REQUEST	Current Zoning: CC, commercial center Proposed Zoning: CC SPA, commercial center, site plan amendment
LOCATION	Approximately 2.60 acres located northwest of the intersection of East Independence Boulevard and Sardis Road North.
CENTER, CORRIDOR OR WEDGE	Corridor
SUMMARY OF PETITION	This petition proposes a site plan amendment to combine two lots to allow for a 56,710 square foot hotel. The proposed maximum square footage is approximate to what is currently allowed. In addition, permitted uses will no longer include retail and restaurants with drive-thru windows.
STAFF RECOMMENDATION	Staff recommends approval of this petition upon resolution of the outstanding issues. The petition is consistent with the <i>East District Plan</i> and the <i>Transit Station Area Principles</i> .
Property Owner	Independence Hospitality, Inc.
Petitioner	HK Patel
Agent/Representative	Monte J. Moreschi
Community Meeting	Meeting is required and has been held. Report available online

PLANNING STAFF REVIEW

RZ1

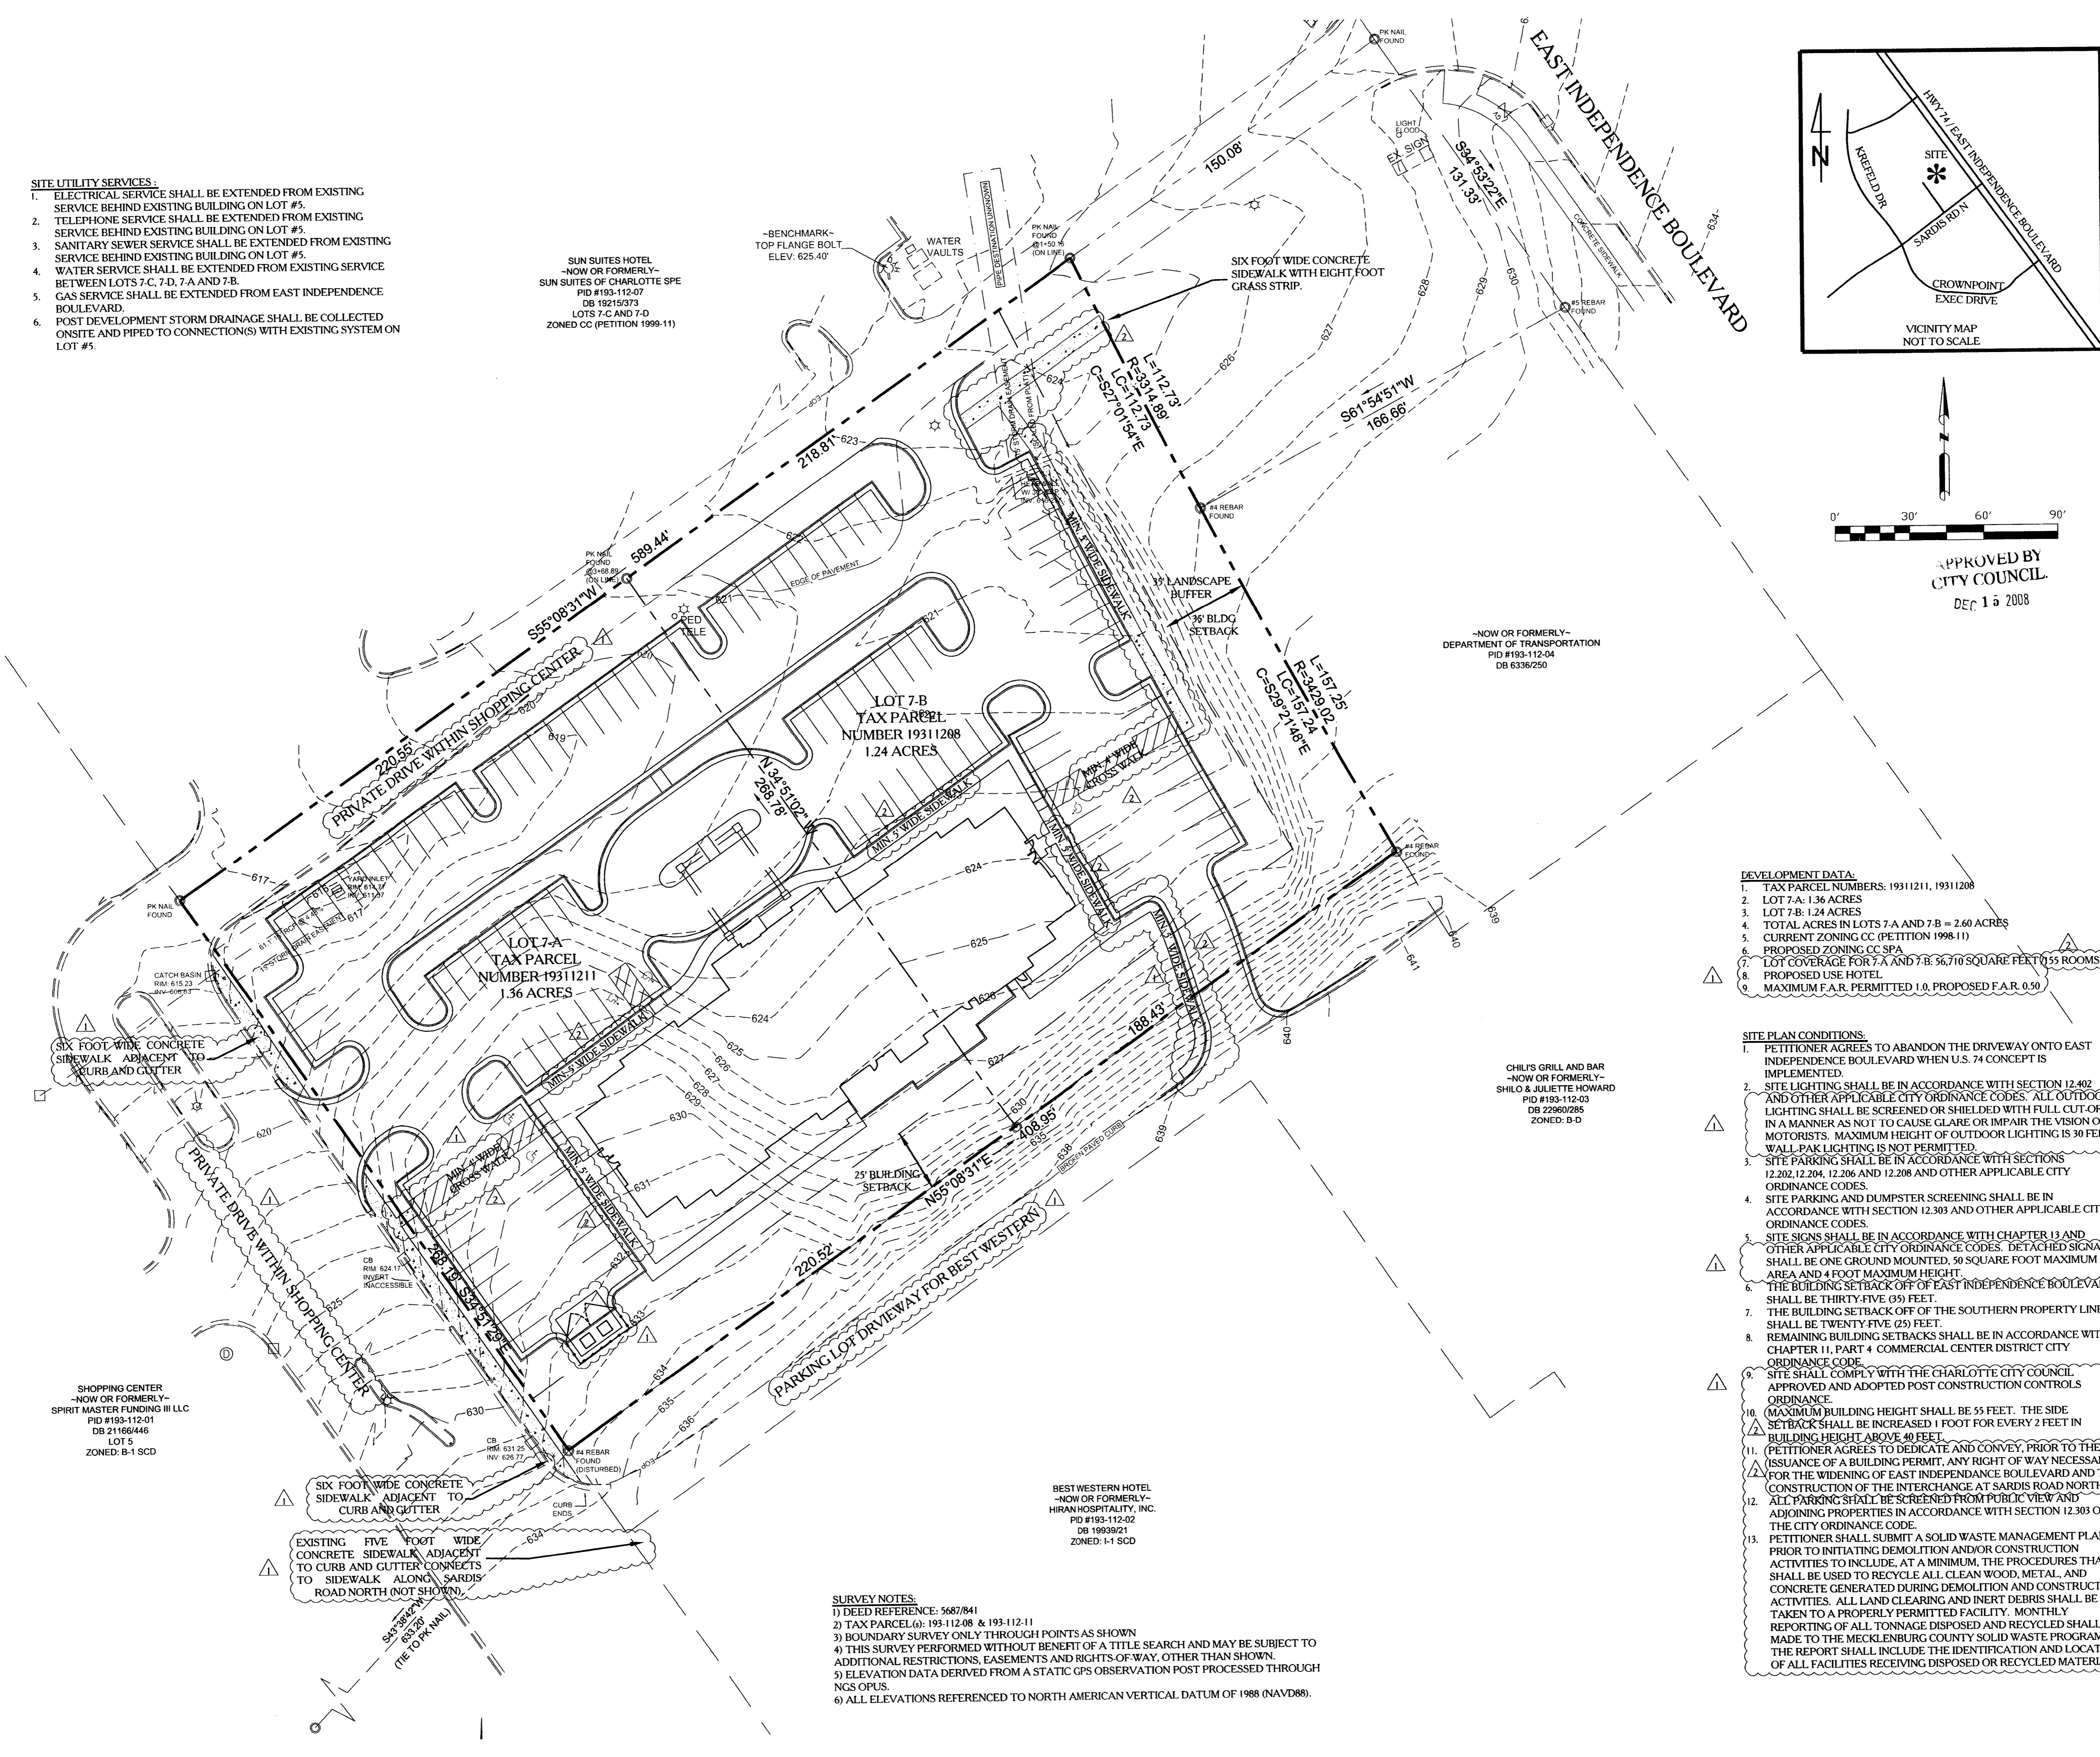
1. The petitioner should label the sidewalk width surrounding building.
 2. The petitioner should specify maximum building height.
 3. The petitioner should clearly delineate and label the boundaries of the rezoning area.
 4. The site plan should indicate the number of parking spaces required and provided.
 5. The petitioner should amend Note 11 to state that the petitioner agrees to dedicate and convey, prior to the issuance of a building permit, any right-of-way necessary for the widening of East Independence Boulevard and the construction of the interchange at Sardis Road North.
 6. A note should be added that six foot sidewalk with eight foot planting strip will be provided to East Independence Boulevard if permission is granted from property owner.
 7. The petitioner should specify how detached sign will be illuminated.
-
